Your Ref: OWQC20757
Our Ref: R/183/18/HH
Please ask for:
Ms S Allen

Front ground floor extension, hip pitched roof extension to form 2 new bedrooms and bathroom in roof space with dormer extension to side, 2 velux windows provided in existing roof slopes.

8 Acre Close Rustington

Thank you for your internet comments made on 29th November 2018 which has been recorded as **'an objection'** with the comments as follows:

Amended plans for Mr. Mrs J. Edwards
at N°8 Acre Close Rustington to
planning application N° R/183/18/H.

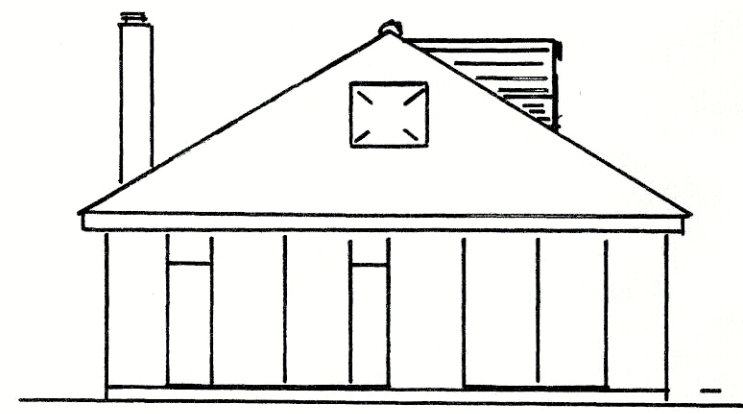
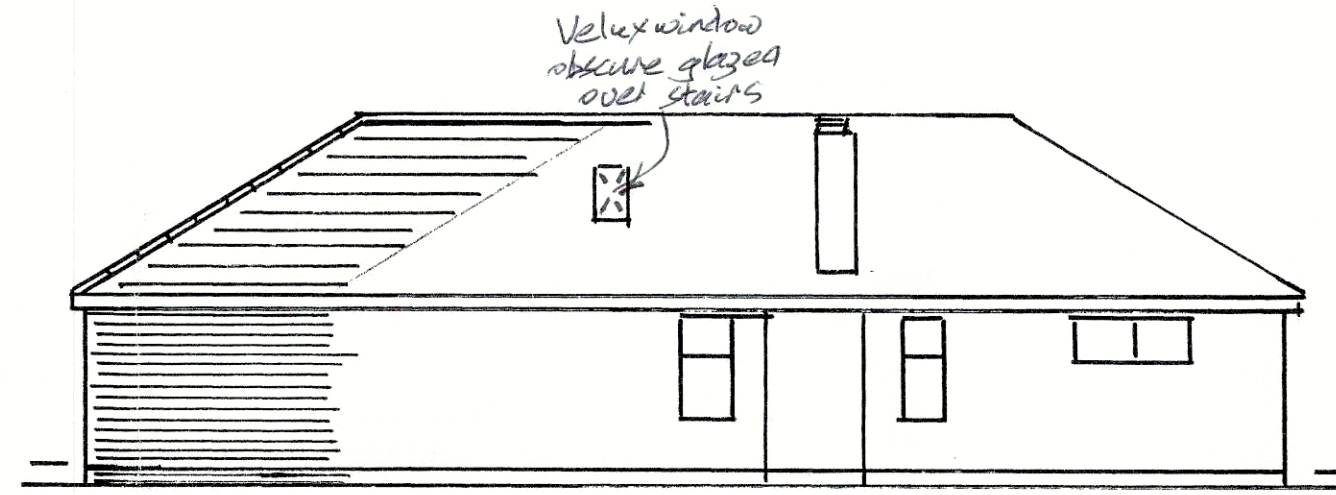
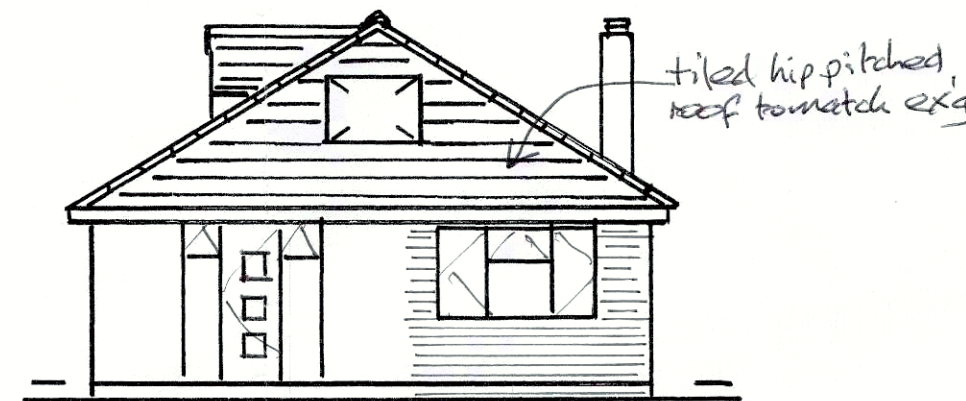
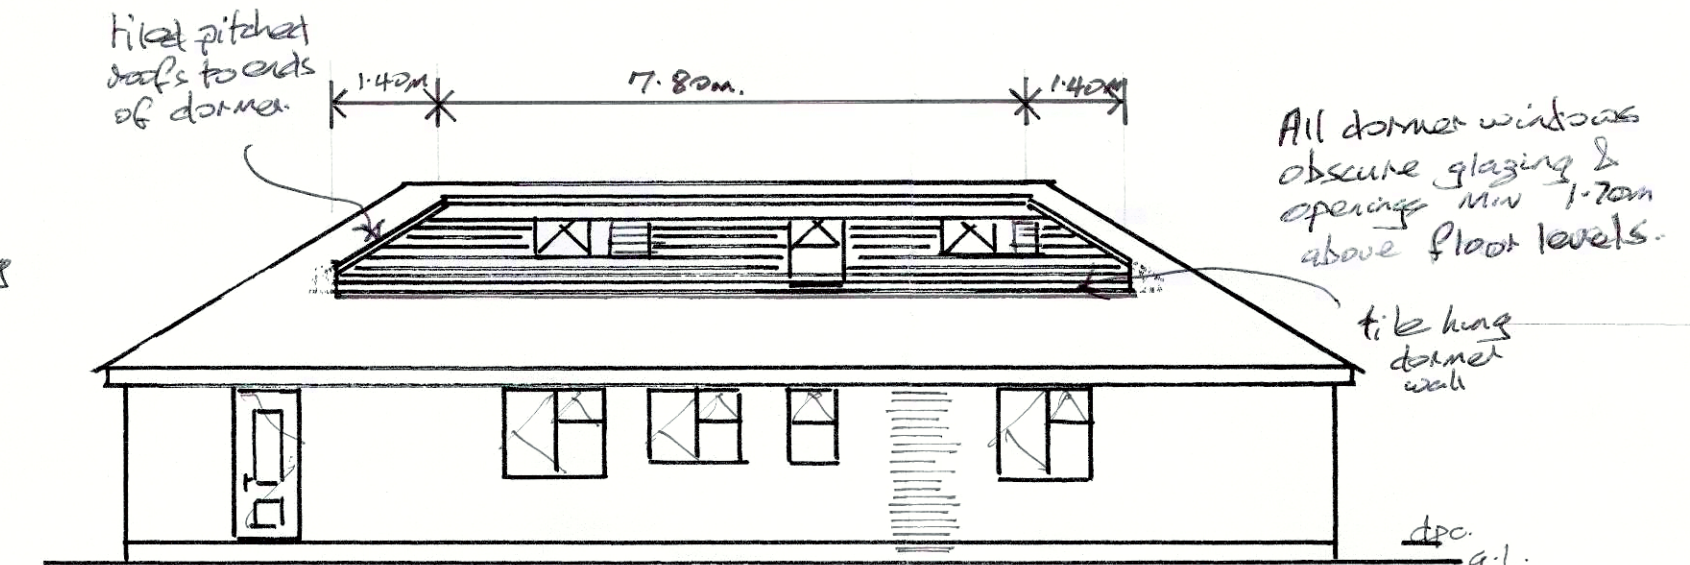
(i) The proposal would result in a severe loss of privacy for the occupier of No. 7 Acre Close, by reason of overlooking to an unacceptable degree. This would most certainly adversely affect the peaceful enjoyment and amenities of the occupier of the aforementioned property

(ii) The proposal would be out of keeping with the street scene and surrounding area overall.
